CITY OF ALBUQUERQUE

**Re: 5th and Fruit Parking Lot Grading/Drainage Improvements Plan
Engineer's Stamp date 12-10-09 (J14/D100)**

**Re: 5th and Fruit Parking Lot, SW Corner of 5th Street and Fruit Avenue NW,
Traffic Circulation Layout**

Re: 5th and Fruit Parking Lot Paving Improvements
Engineer's Stamp date 11-9-09 (J14/D100)

DRAINAGE AND GRADING PLAN

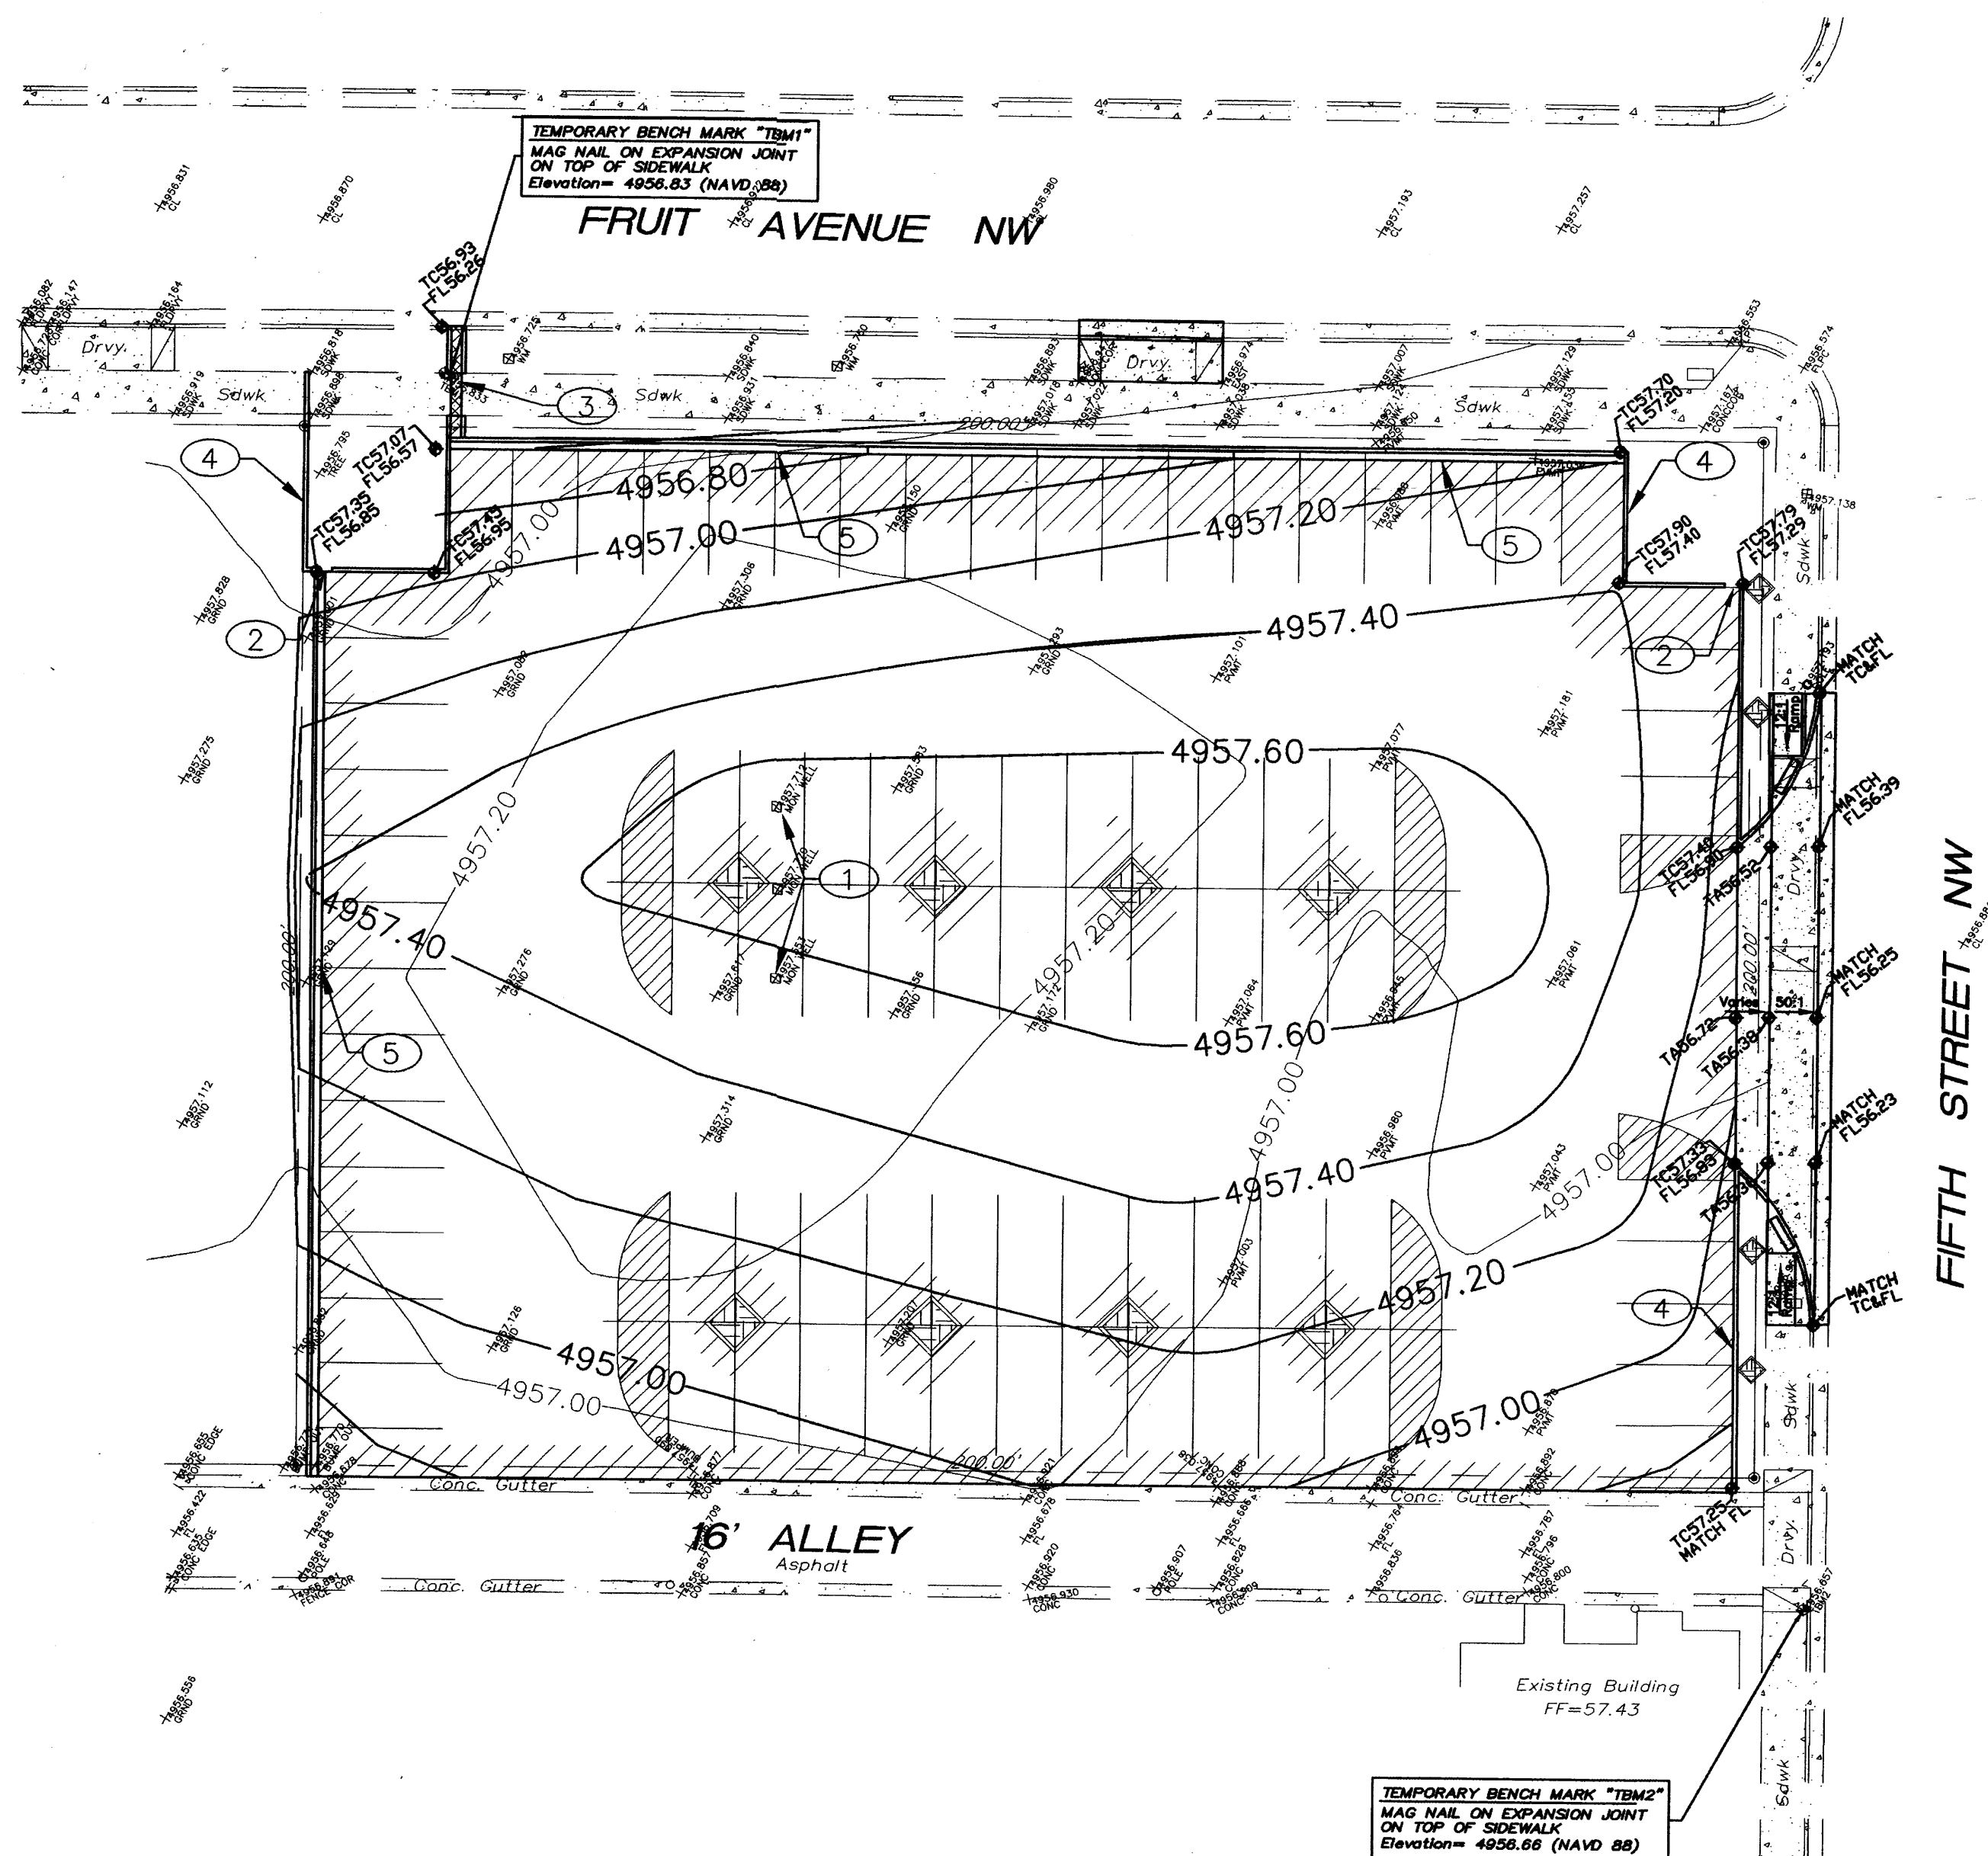
- The steel plate for the sidewalk culvert must extend to the face-of-curb. Include SO 19 notes on the plan. Please provide 2 copies of the plan when an SO 19 Permit is required, because the inspector gets a copy.
- Curb or similar is required along the western property line to prevent runoff from entering the lot to the west.

PARKING LOT LAYOUT SITE PLAN

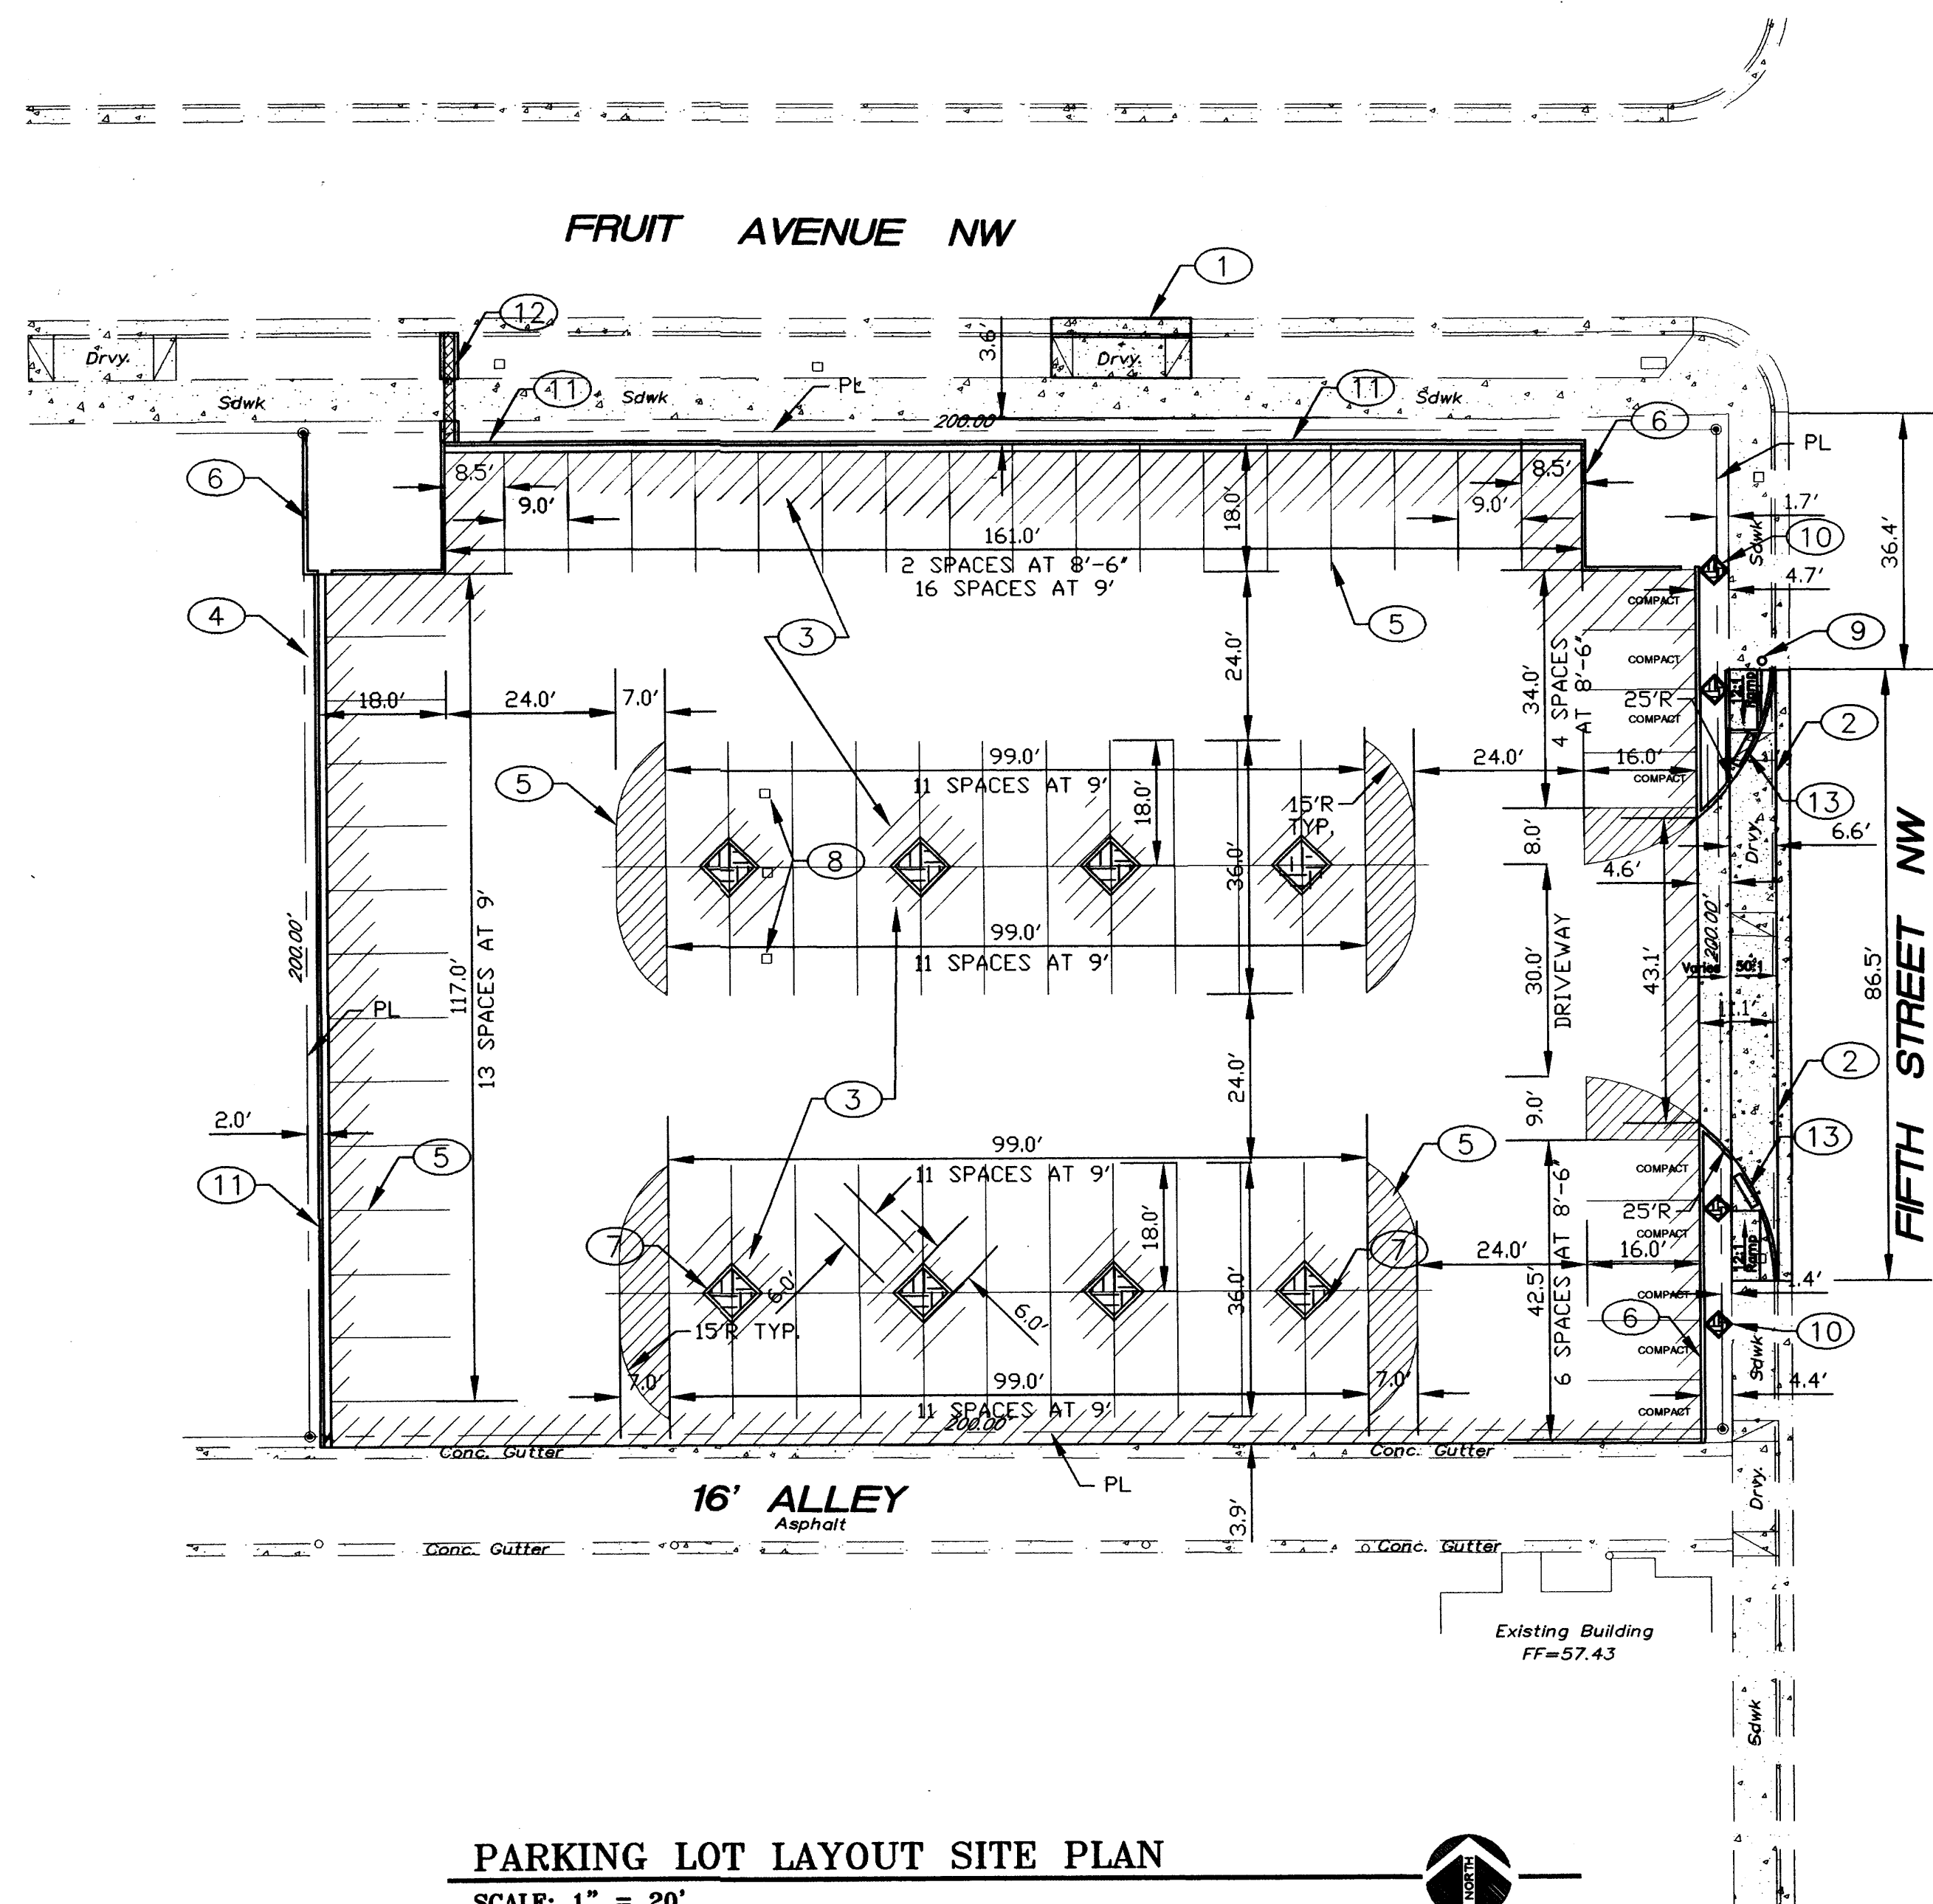
- ✓1. Include two copies of the traffic circulation layout at the next submittal.
2. A light pole cannot be located within the proposed wheelchair ramp; please relocate the proposed driveway further south.
3. All ramps located within the City of Albuquerque right of way must have truncated domes.
4. How will the parking spaces adjacent to the alleyway be separated from traffic? Please clarify.
